Traffic Impact Study_v2 redlines.pdf Markup Summary 3-7-2022

EL PASO COUNTY, CO  
MAIN ST. AND SECURITY BLVD.  
ACCESS EXHIBIT

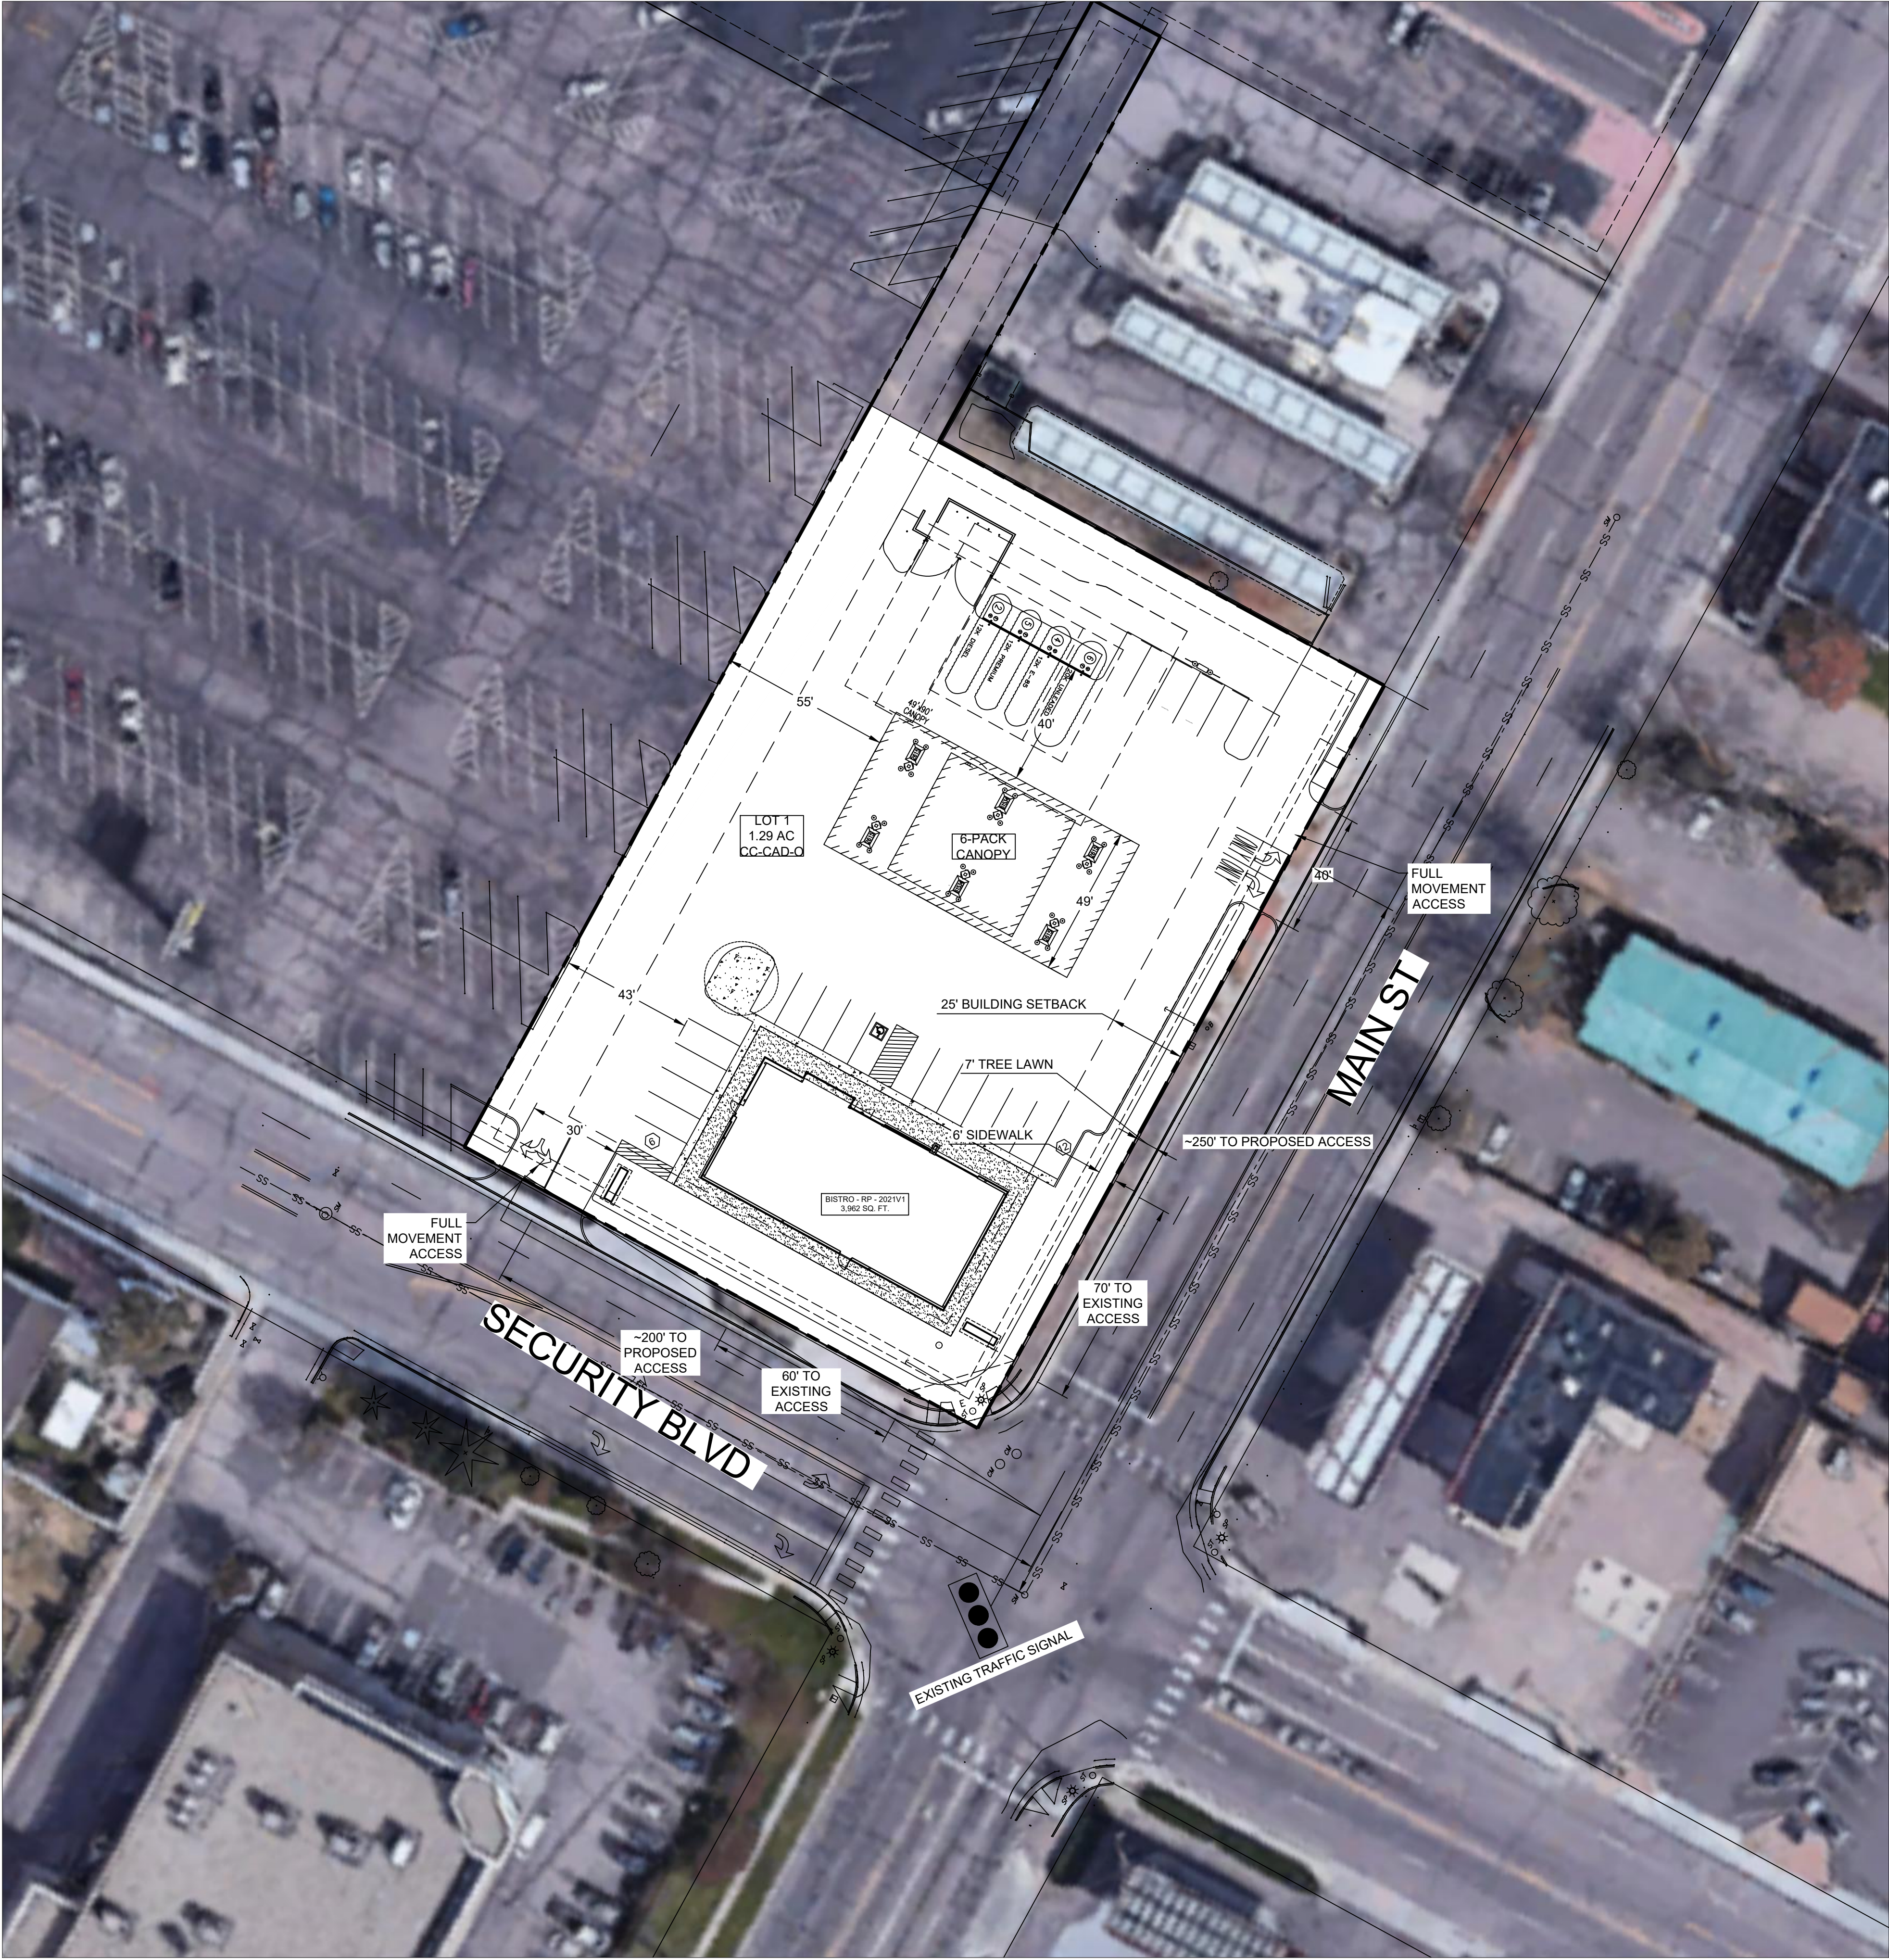
Unresolved. Please provide an analysis for building a narrow median on each road to ensure that the access points will only allow right in right out movements. Full movements will not be allowed on either access point.

Unresolved. Please remove inconsistencies between traffic study and deviation requests. TIS requests full movement access points while the deviation requests request right in right out movements. Full movements will not be allowed onto Security Blvd and Main Street. Please revise TIS to match the request of the deviation, which is to allow right-in right-out movements onto both streets.

Unresolved. This is not a full movement access. Please call it out as a right-in right-out. Full movements will not be allowed onto either street.

EL PASO COUNTY, CO  
MAIN ST. AND SECURITY BLVD.  
SECURITY BLVD. ACCESS EXHIBIT

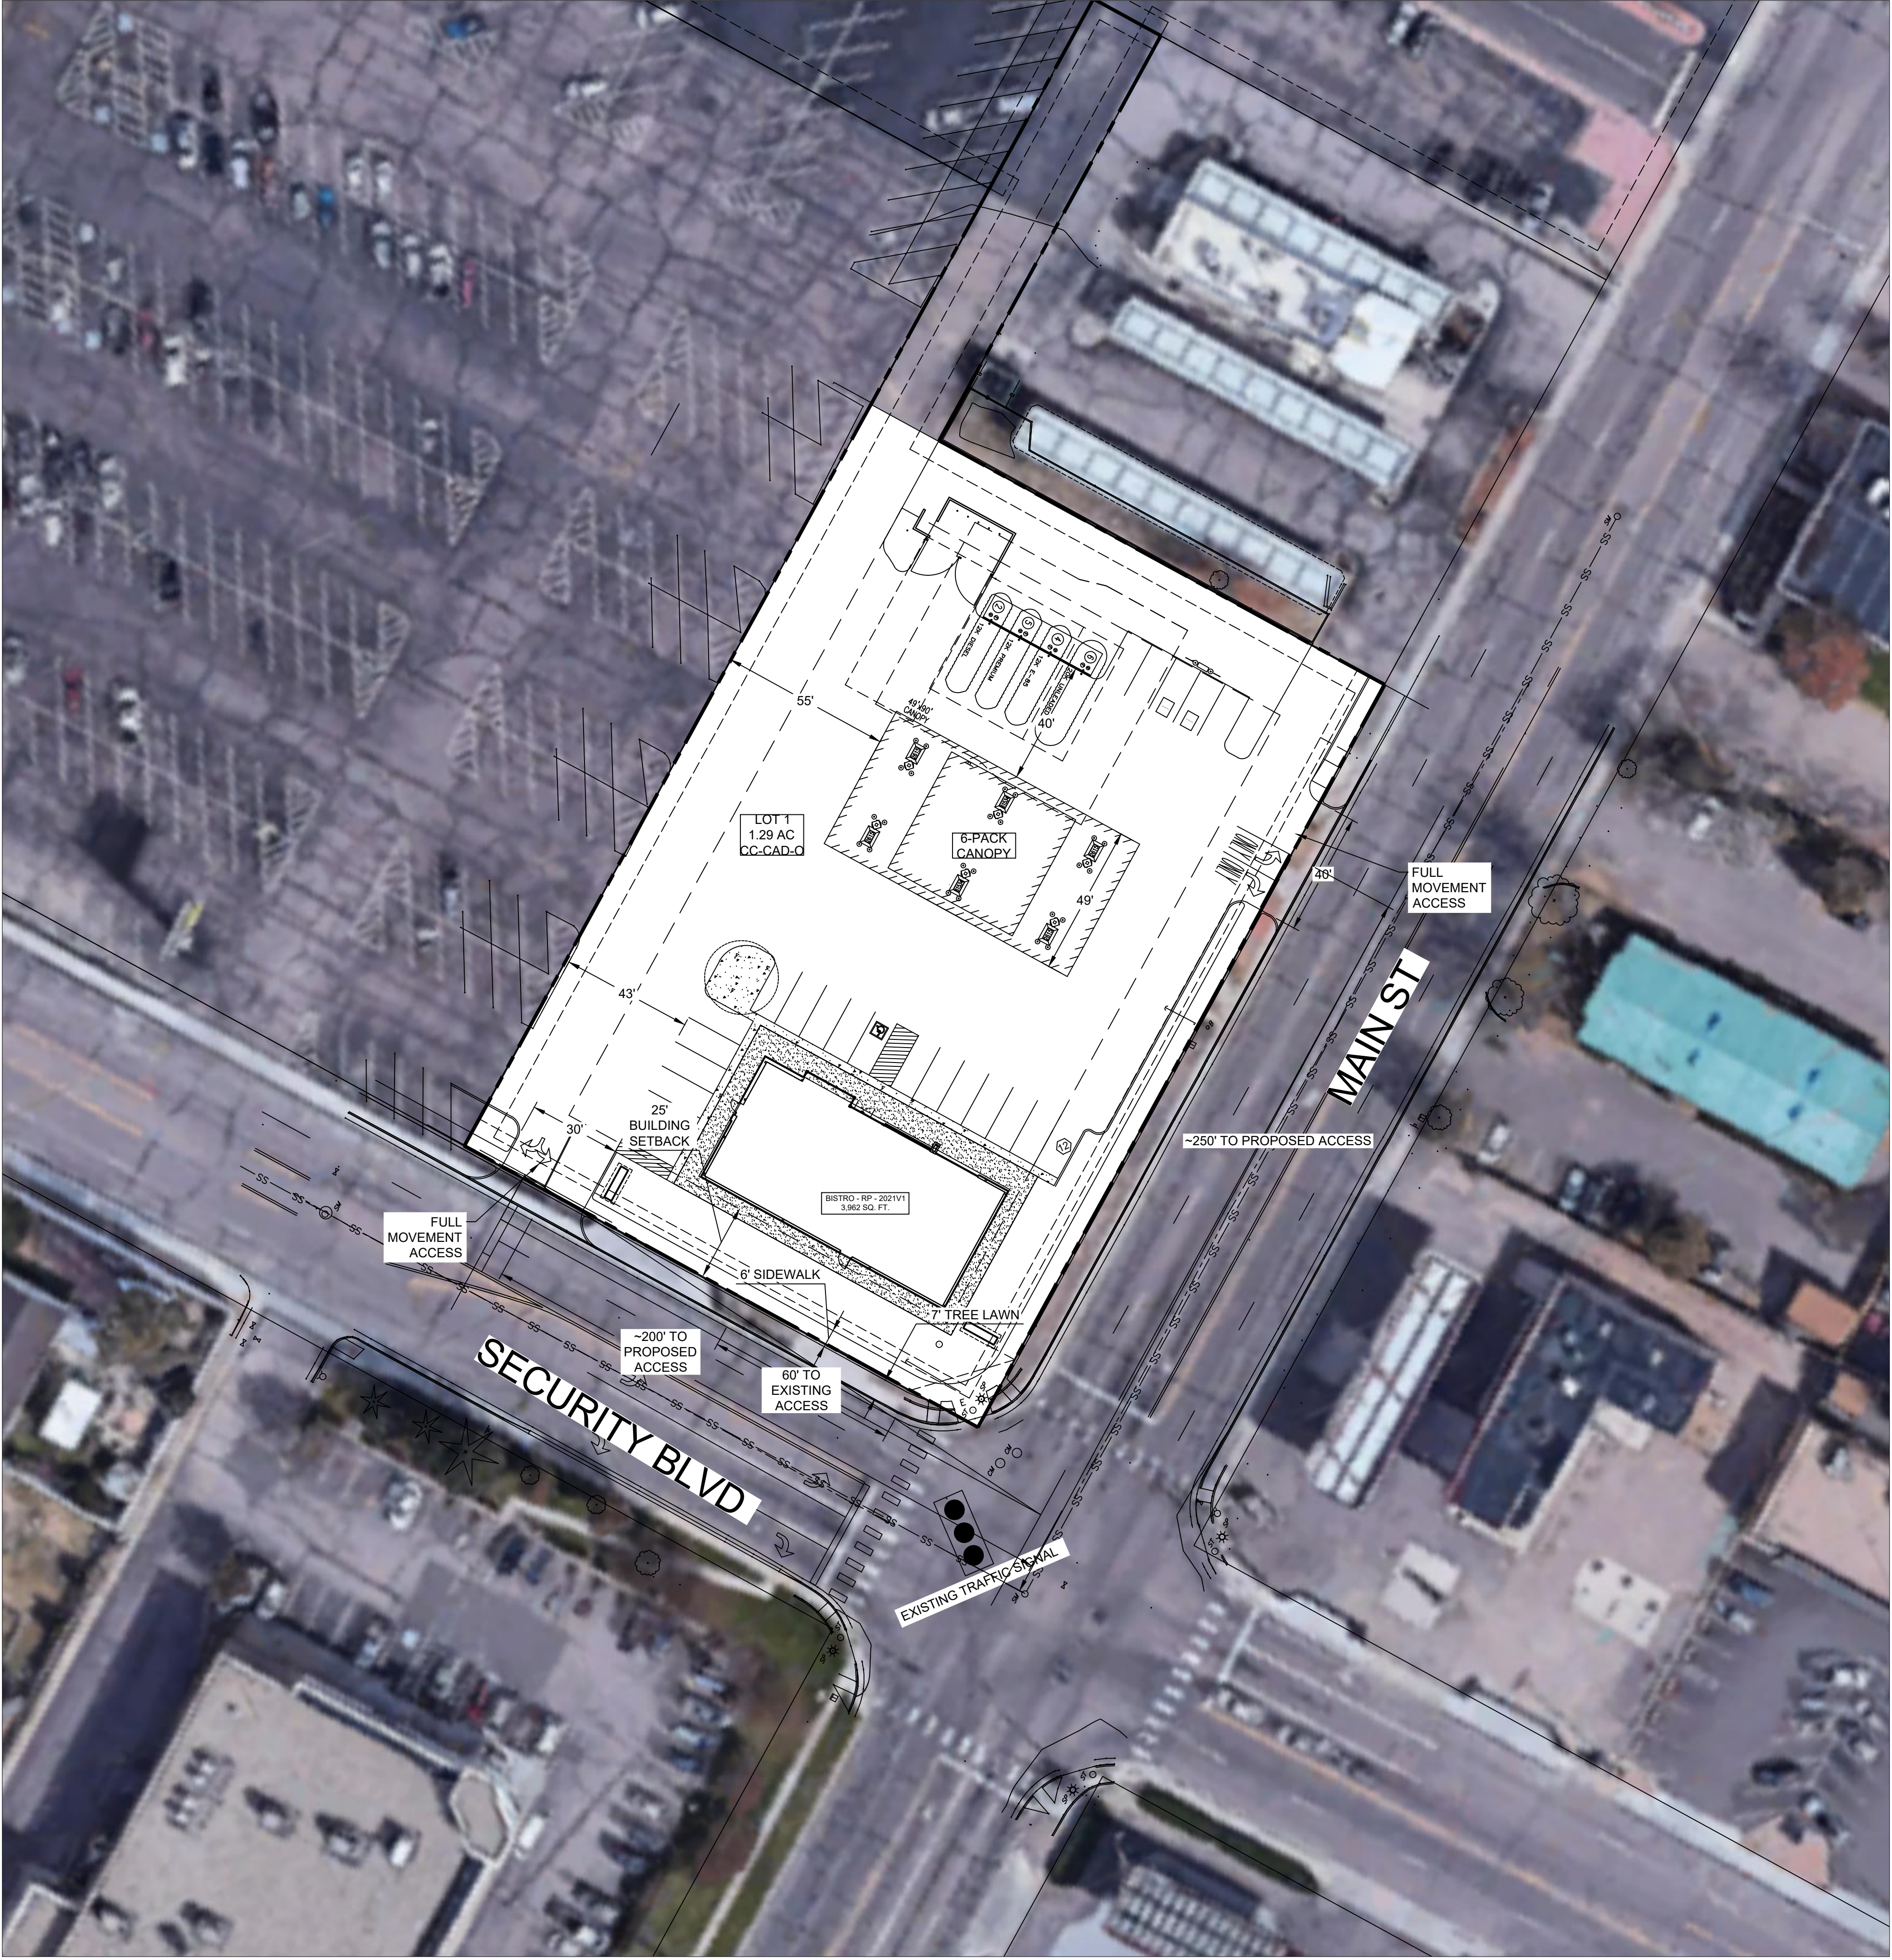
Unresolved. This is not a full movement access. Please call it out as a right-in right-out. Full movements will not be allowed onto either street.
